**From:** Will Conway  
**Sent:** Tuesday, January 02, 2018 4:00 PM  
**To:** 'Jean Fraser'  
**Cc:** 'Alexander M. Green'  
**Subject:** RE: East Tower and Visitors Parking Garage Site Plan

**Attachments:** Written Submission A -1 East Tower Data Sheet.pdf; Written Submission A -2 Visitor Garage Data Sheet.pdf; Written Submission I -1 Construction Management Plan Update January 2.pdf; Written Submission S - 9A Maintenance of Traffic January 2.pdf; Written Submission S-10 Project Description.pdf; Plan 14C East Tower East Elevation January 2.PDF; Plan 14D East Tower North Elevation January 2.PDF; Plan 14E East Tower West Elevation January 2.PDF; Plan 14F East Tower South Elevation January 2.PDF; Plan 14K Visitor Garage East Elevation January 2.PDF; Plan 14L Visitor Garage North Elevation January 2.PDF; Plan 14M Visitor Garage West Elevation January 2.PDF; Plan 14N Visitor Garage South Elevation January 2.PDF

**From:** Jean Fraser [<mailto:jf@portlandmaine.gov>]  
**Sent:** Wednesday, December 27, 2017 10:46 AM  
**To:** Will Conway <[wconway@sebagotechnics.com](mailto:wconway@sebagotechnics.com)>  
**Subject:** MMC East Tower and Visitors Parking Garage Site Plan

PERKINS+WILL
 2018.03.22 DOCUMENT SET

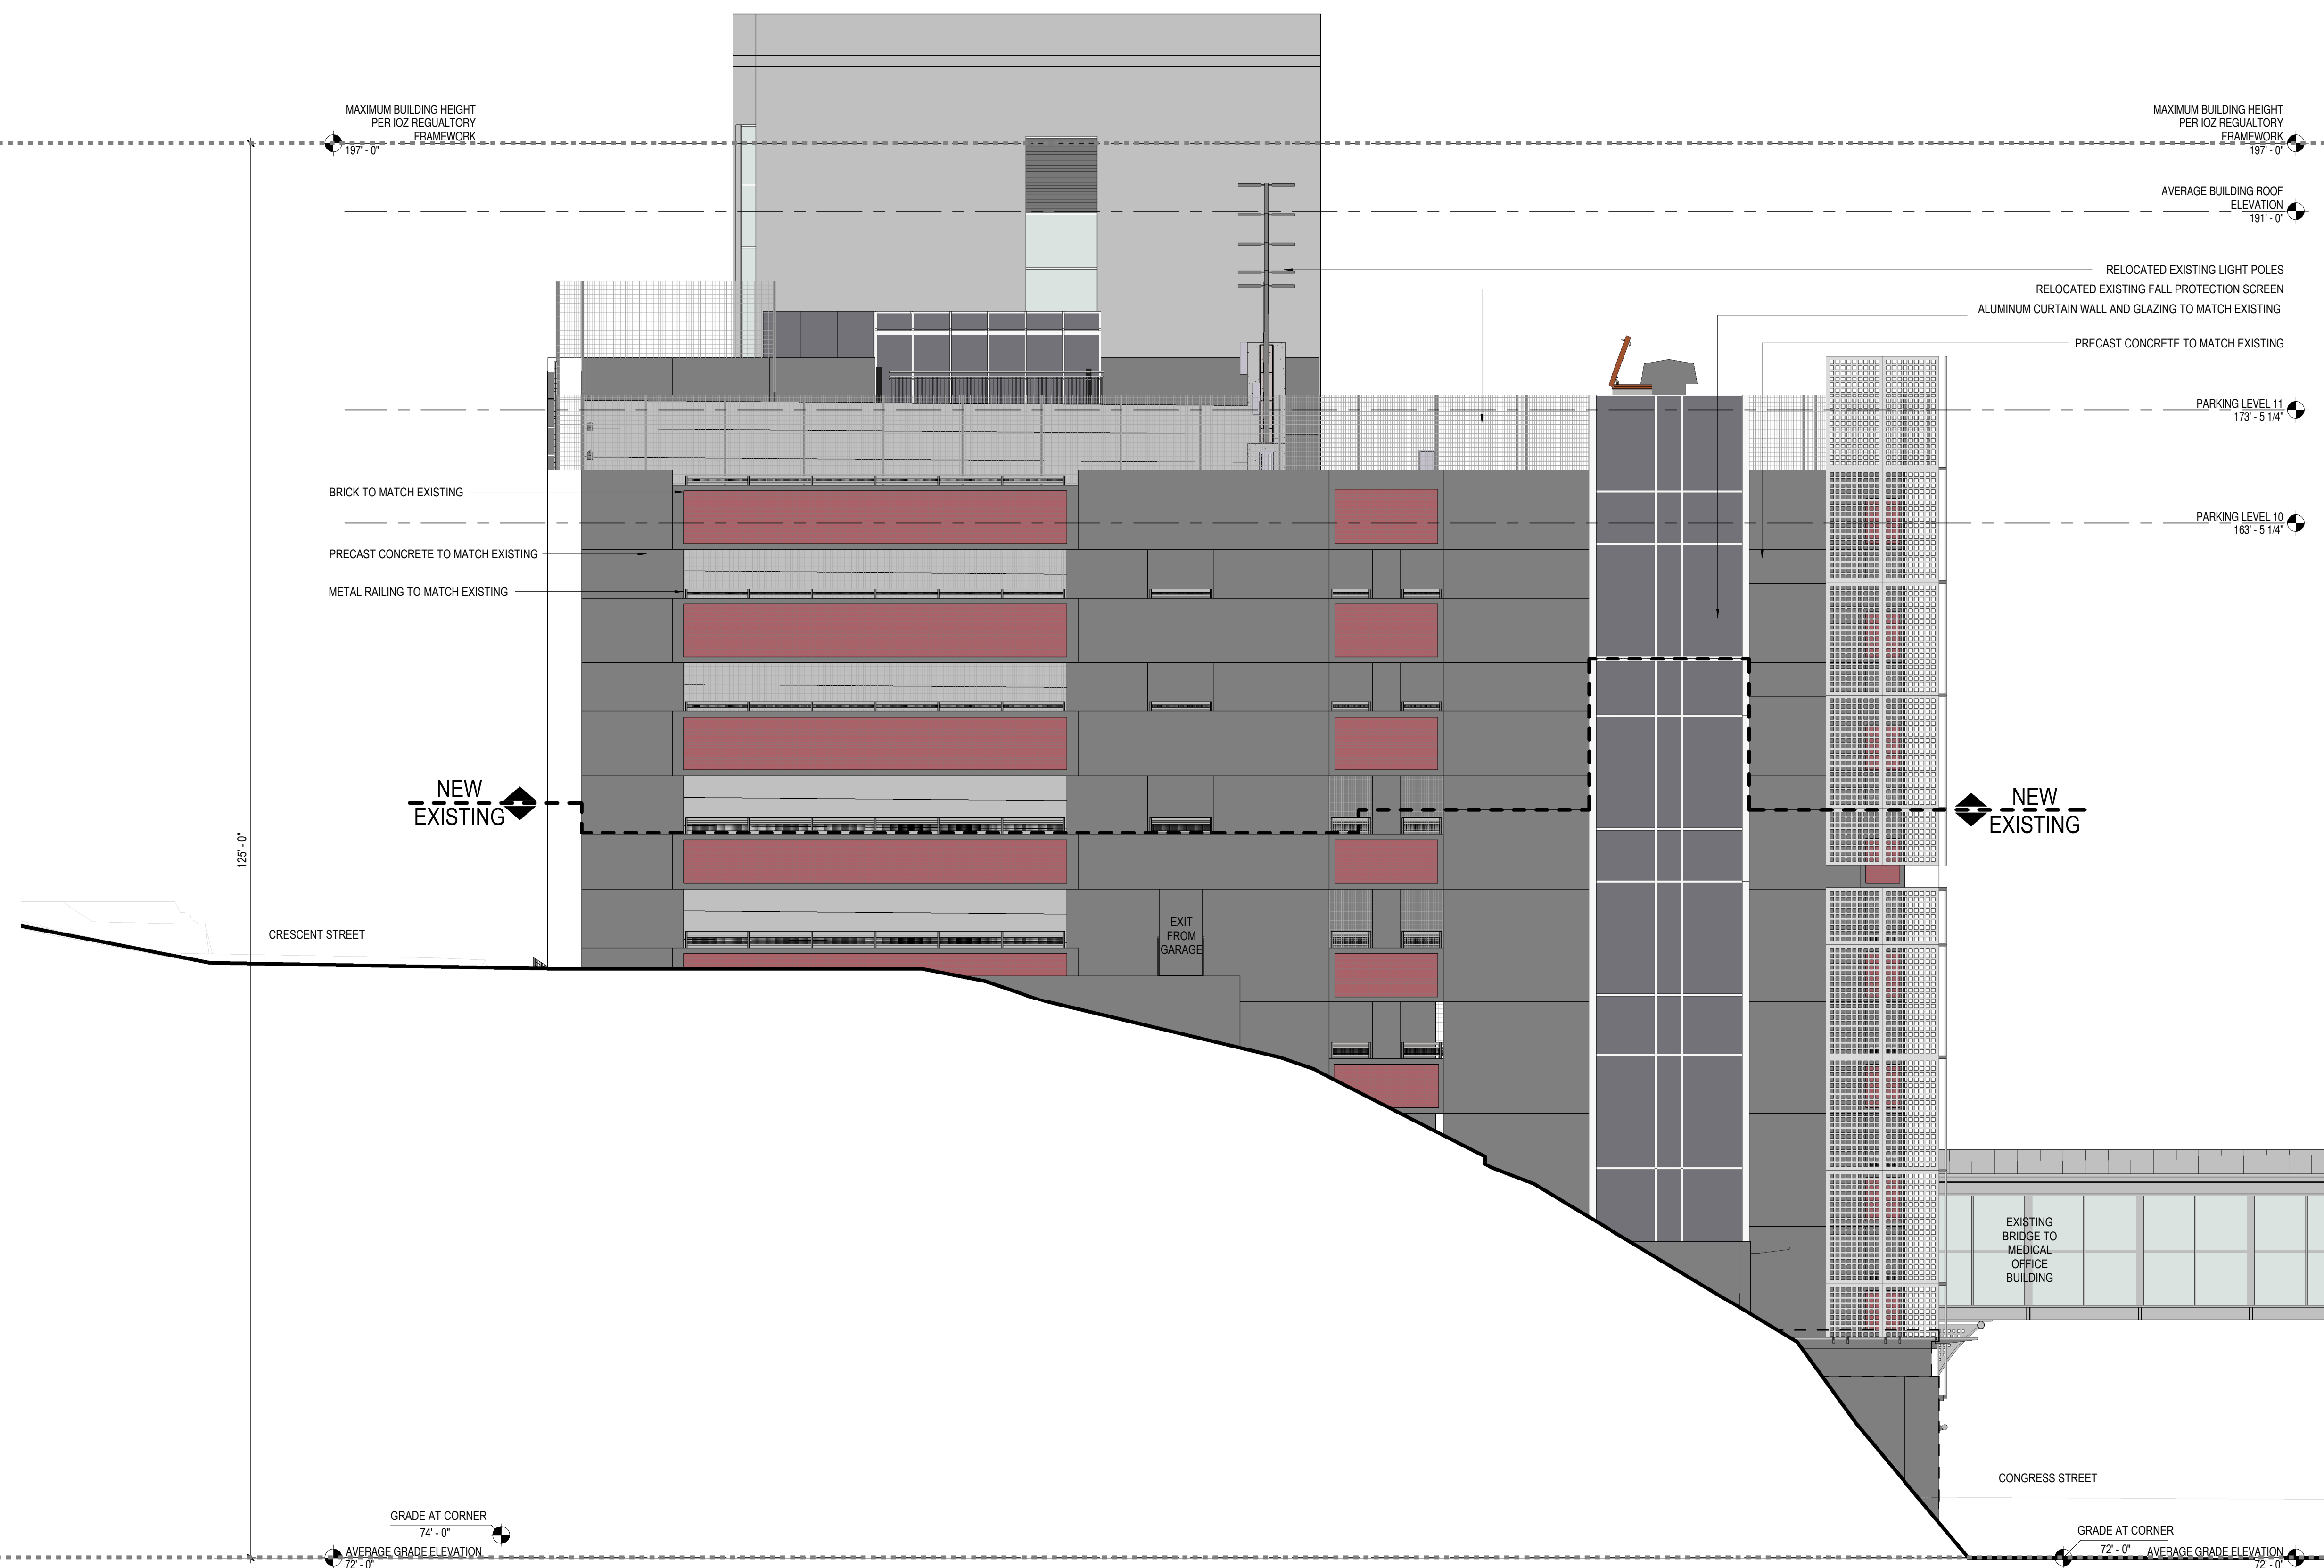
- Separate data sheets for each building See Written Submission A-1 and A-2.
- Elevations that show the existing compared to the proposed (either annotate the proposed elevations, or send in existing elevations or matching existing photos); See revised Plans 14C – 14N dated January 2.

- Elevations need to show the average grade (measured in accordance with our ordinance). See revised Plans 14C- 14N dated January 2.
